**KIRKLEES METROPOLITAN COUNCIL
INVESTMENT & REGENERATION SERVICE**

DELEGATED DECISION TO DETERMINE PLANNING APPLICATIONS

Reference No:	2026/62/91390/W
Site Address:	259, New Hey Road, Oakes, Huddersfield, HD3 4GH
Description:	Erection of two storey side extension
Recommending Officer:	Jennifer Booth

DECISION - Refuse

3 Front Elevation
1 : 100

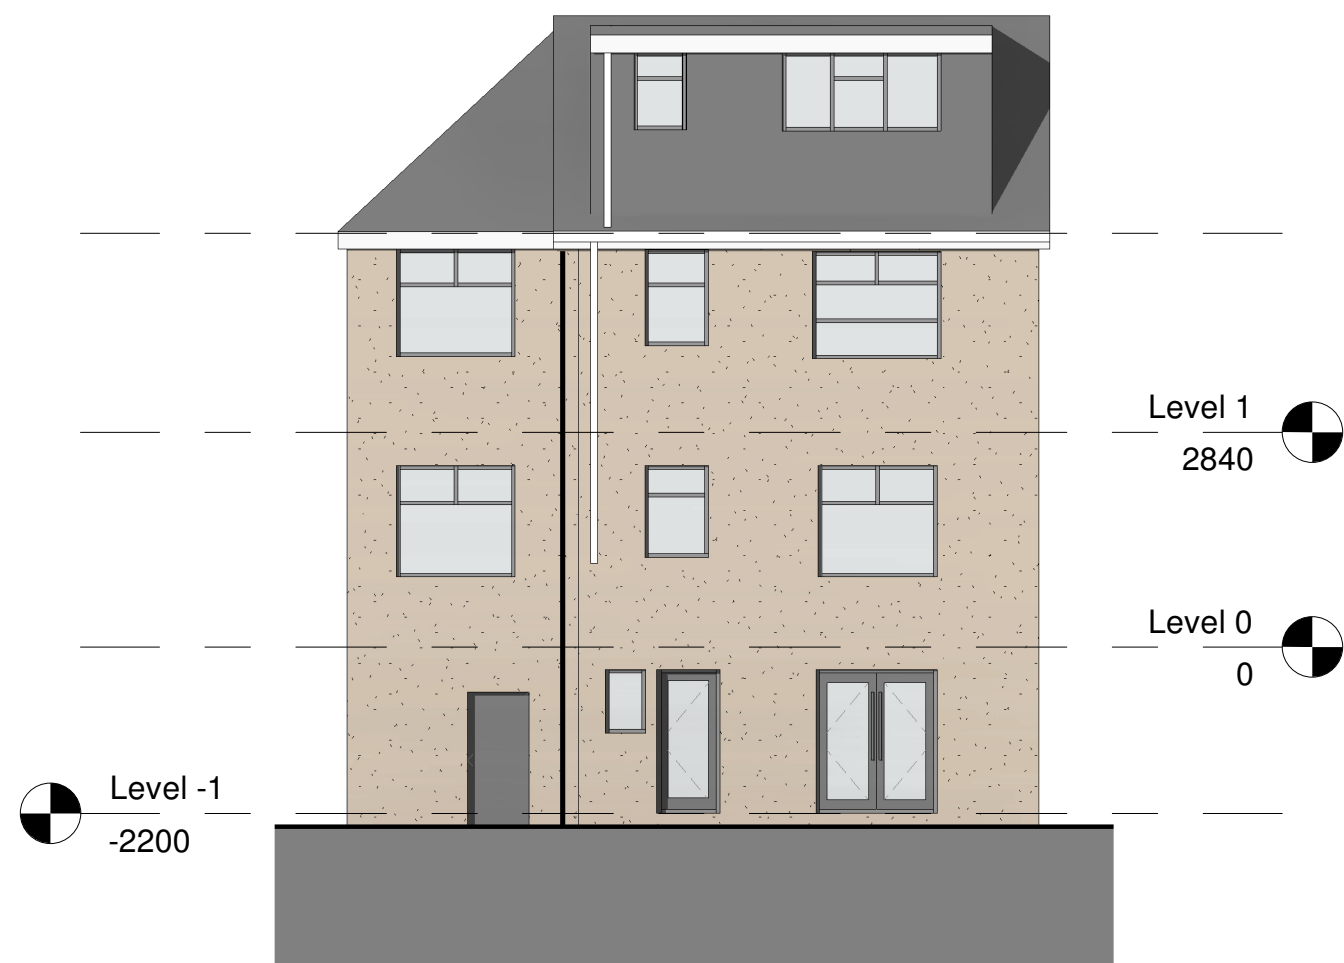
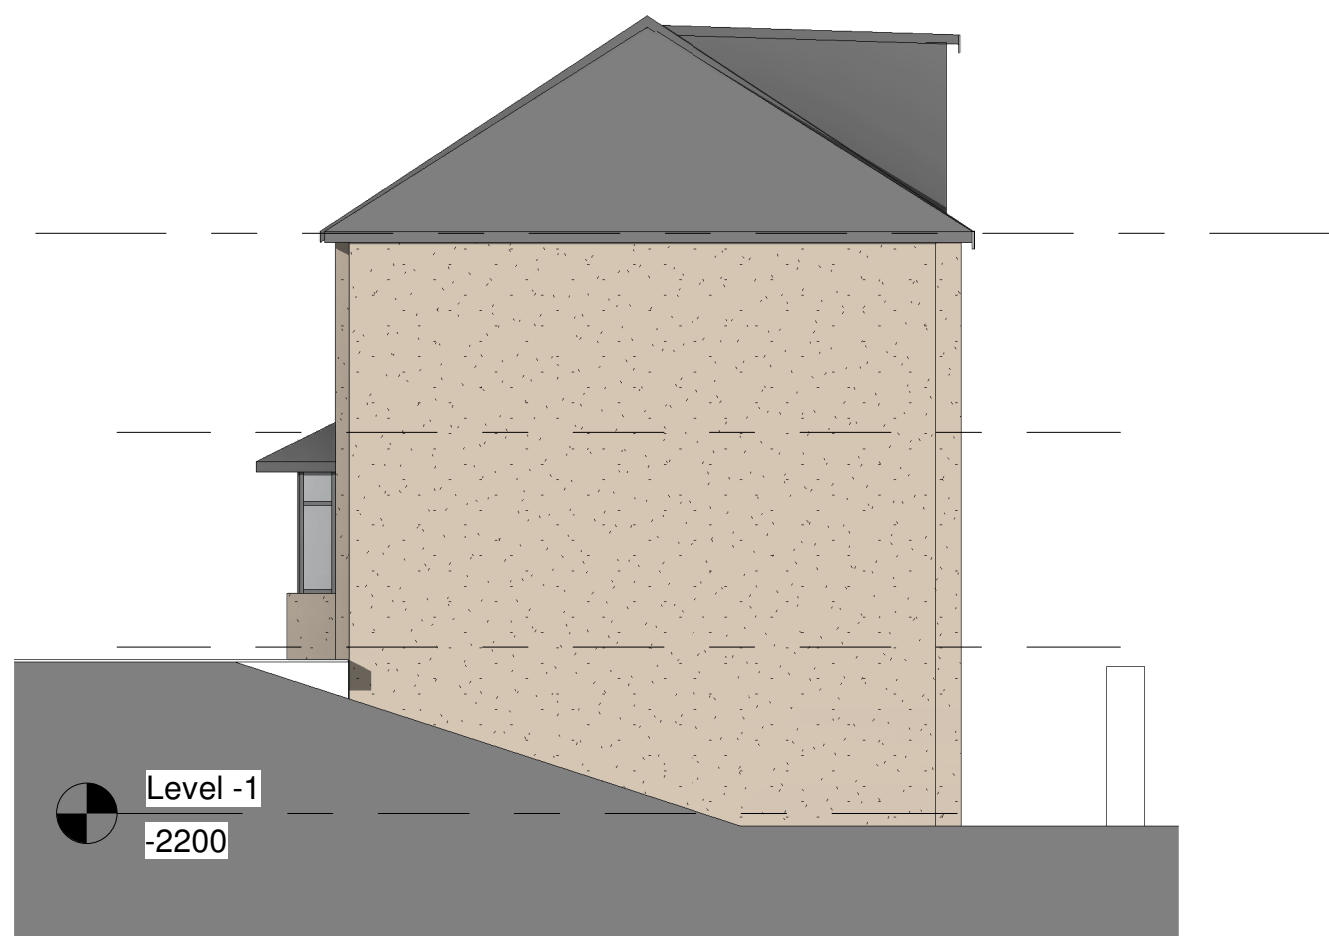
The proposed two-storey side extension includes a hipped roof form and is designed with only a minimal set-back from the principal elevation. This lack of the required set-back, combined with the roof design, results in a form that is out of character with the existing dwelling and the surrounding street scene. Although materials are proposed to match the host property, the overall design is considered to be visually incongruous and unacceptable in terms of its impact on the visual amenity of the area.

The proposed two-storey side extension, by virtue of its minimal set-back and hipped roof form, would result in an incongruous addition that is out of character with the host property. The design fails to respect the architectural integrity of the dwelling and would have a detrimental impact on the visual amenity of the area. To permit the proposals would be contrary to Policy LP24 of the Kirklees Local Plan, KDP1 & KDP2 of the House Extensions & Alterations SPD and Chapter 12 of the National Planning Policy Framework.

1 Side Elevation 1
1 : 100

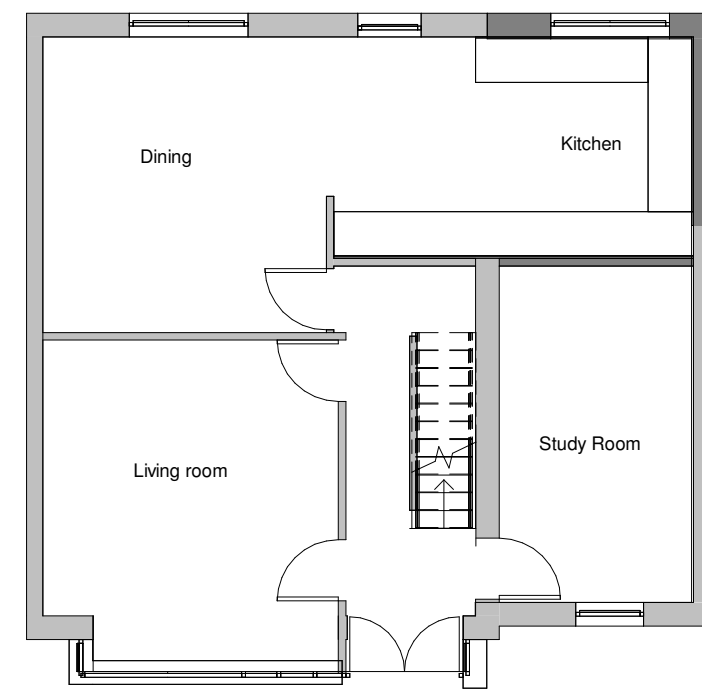
The proposed side extension would increase the extent of walling close to the shared boundary with the adjacent dwelling. The neighbouring property aligns with the rear corner of the host dwelling and is situated at a lower land level, with habitable room windows—specifically bedrooms—on the front elevation that would be affected. Given the topography and the spatial relationship between the properties, the side extension is considered to result in a significant overbearing impact on the neighbouring amenity.

The side extension would significantly increase the extent of walling close to the shared boundary with 261 New Hey Road. Given the neighbouring property's alignment and lower land level, the proposal would result in an unacceptable overbearing impact on habitable room windows, particularly those serving bedrooms on the front elevation. To permit the proposals would be contrary to Policy LP24 of the Kirklees Local Plan, KDP6 of the House Extensions & Alterations SPD and Chapter 12 of the National Planning Policy Framework.
